LOT T-1B OLD US 421  
SCALE 1" = 40'-0"

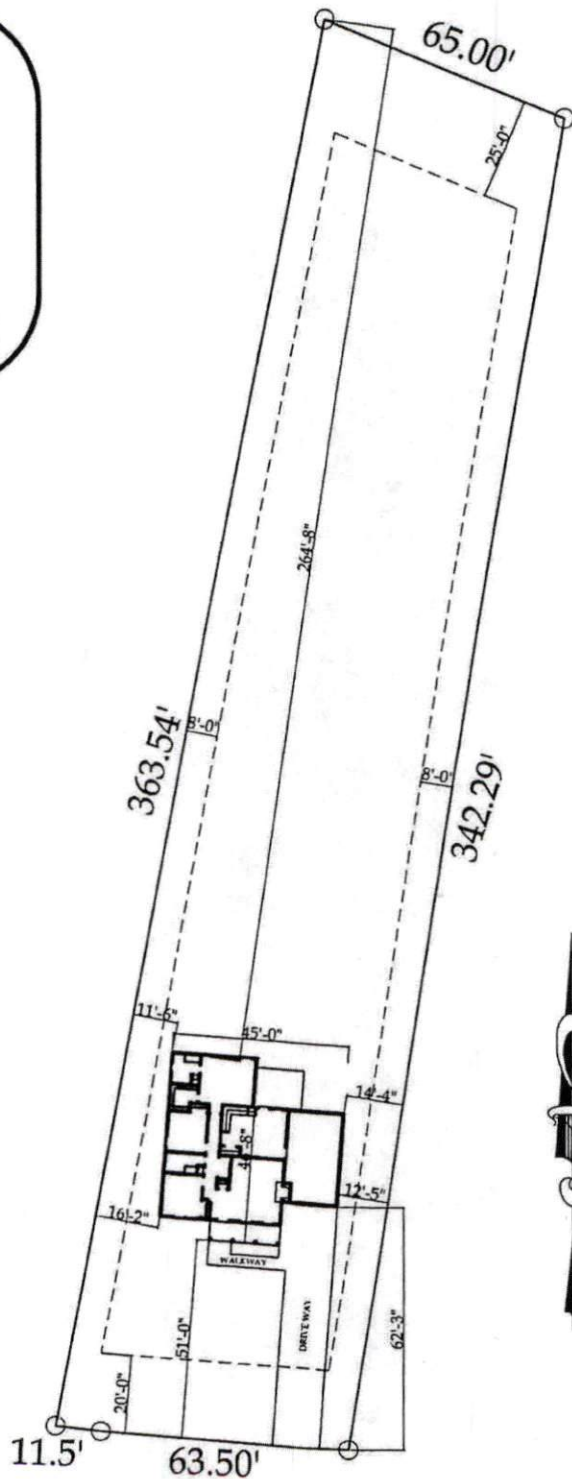
9-20-21
Need Irons
Need House Spher
Need prop lines

Show profile locations and other site features (dimensions, references or benchmark, and North)
